PLANNING APPLICATION CONSULTATION RESPONSE

Application Number:	3/2022/1116
Proposal:	Discharge of Condition 9 (Drainage Scheme) of planning application 3/2019/1104.
Location:	Land at Hawthorne Farm, Hawthorne Place, Clitheroe, BB5 2HU

Lead Local Flood Authority Position

The Lead Local Flood Authority is currently **unable to recommend the discharge of condition 9** on planning decision 3/2019/1104 on the basis of:

Project Name:
HAWTHORNE FARM CLITHEROE
 Client:
PERSIMMON HOMES
 Designed: **D.A.** Drawn: **D.A.** Checked: **R.A.** Scale: **1:250**
DRAINAGE LAYOUT
 Project No:
19310
 Drawing No:
19310-EDGE-XX-XX-DR-C-C2001 P18
PRELIMINARY NOT FOR CONSTRUCTION

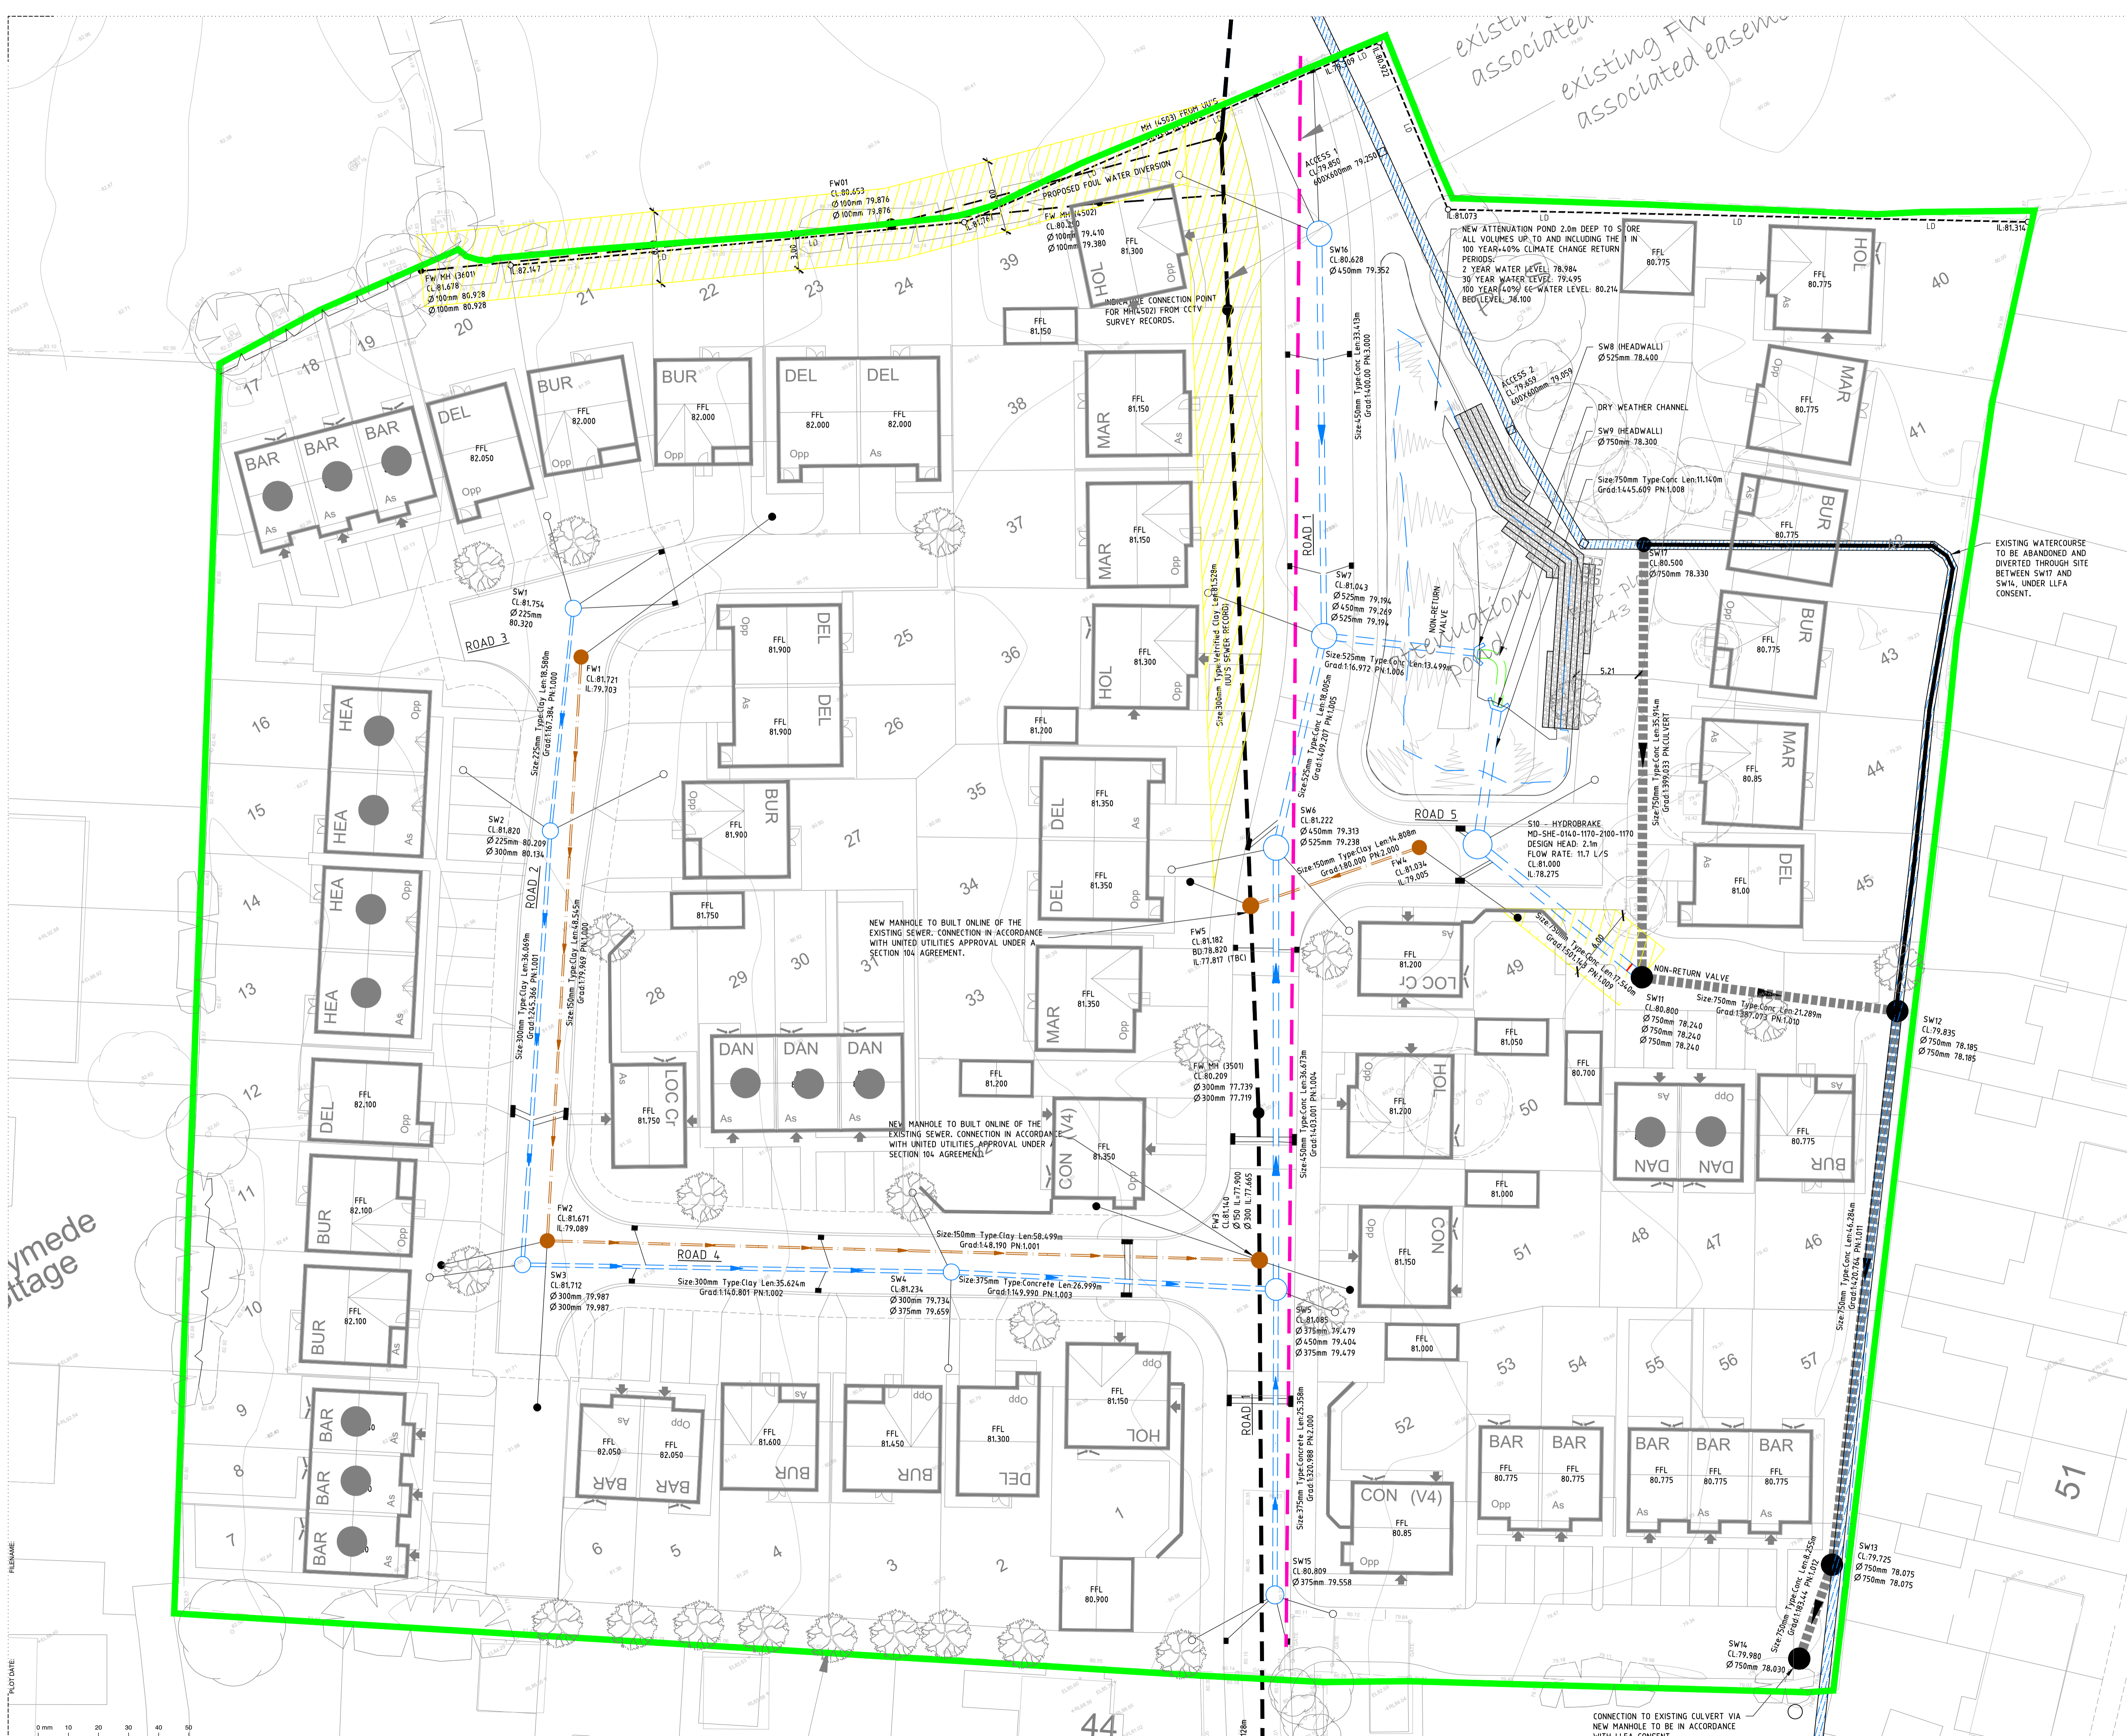
- It is unclear from the drainage layout, the connection point that surface water will be discharged at 11.7l/s.
- The drainage layout fails to provide cover levels for the manholes in order to ensure that in the event of exceedance from manhole chambers the surrounding areas are not at risk of flooding due to their finished floor levels.
- The exceedance routes should take into consideration the flow paths of exceedance for the entire site, in order to ensure that they can be directed away from vulnerable areas from the development.
